Transport
for NSW

Response to Kempsey District Hospital Redevelopment (SSD 5363)

TfNSW has reviewed the document *Transport and Accessibility Study, Kempsey District Hospital Redevelopment, dated 5 April 2013* prepared as part of the Final Schematic Design Report by GTA Consultants.

Figure 5: Location of Bus Stops and New Pedestrian Refuge Island

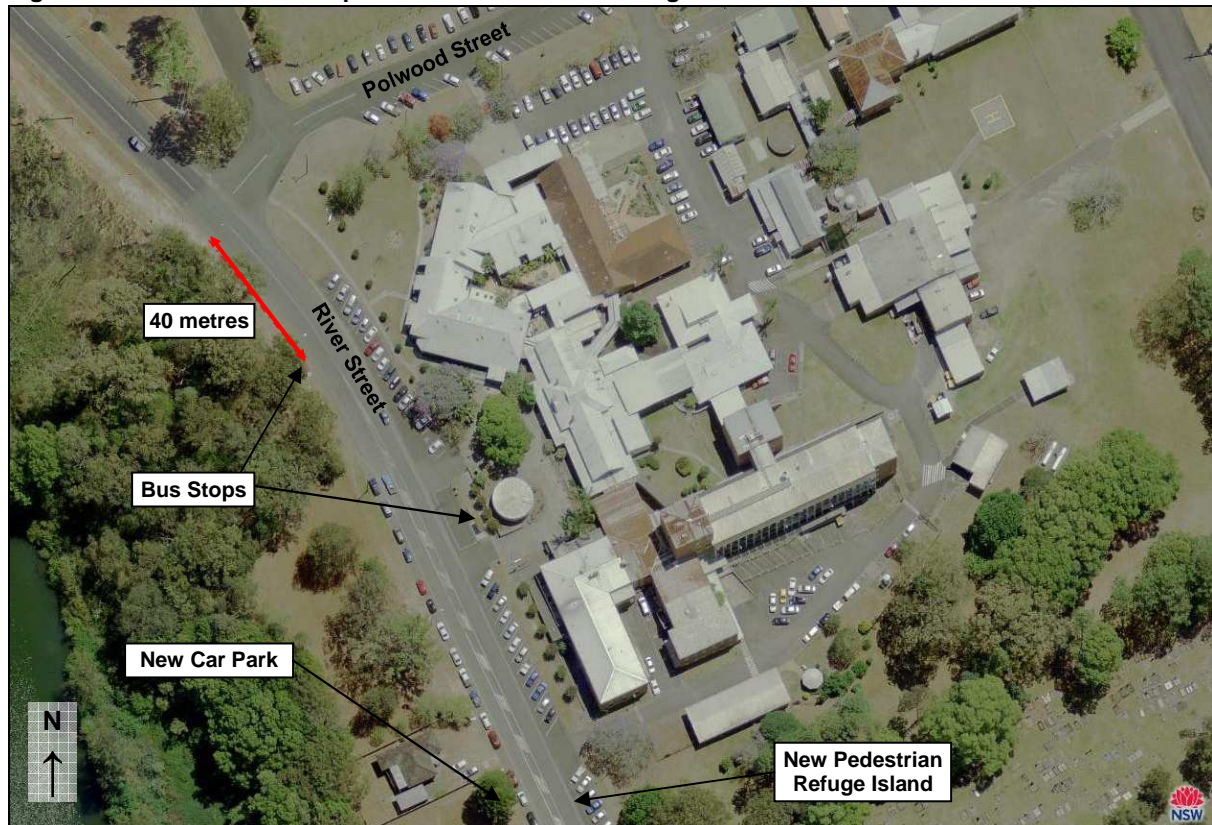
- Pedestrian safety issues at the River Street/Polwood Street intersection - No suitable pedestrian facilities are provided to cross River Street and access to the hospital from the bus stop located on the western side of MR75, adjacent to the River Street/Polwood Street intersection. It is recommended that the applicant relocate the bus stop to the south of the newly proposed car park and pedestrian facility on River Street. This would improve pedestrian connectivity to public transport and pedestrian safety.

- Vehicle safety issues at the River Street/Polwood Street intersection - The existing bus stop arrangement on the western side of MR75, adjacent to the River Street/Polwood Street intersection, requires buses to stop adjacent to right turning traffic and blocking through traffic movements at this location. The recommended bus stop relocation to the south of the newly proposed car park and pedestrian facility on River Street would provide sufficient space to accommodate a suitable protected right-turn treatment at the River Street/Polwood Street intersection.
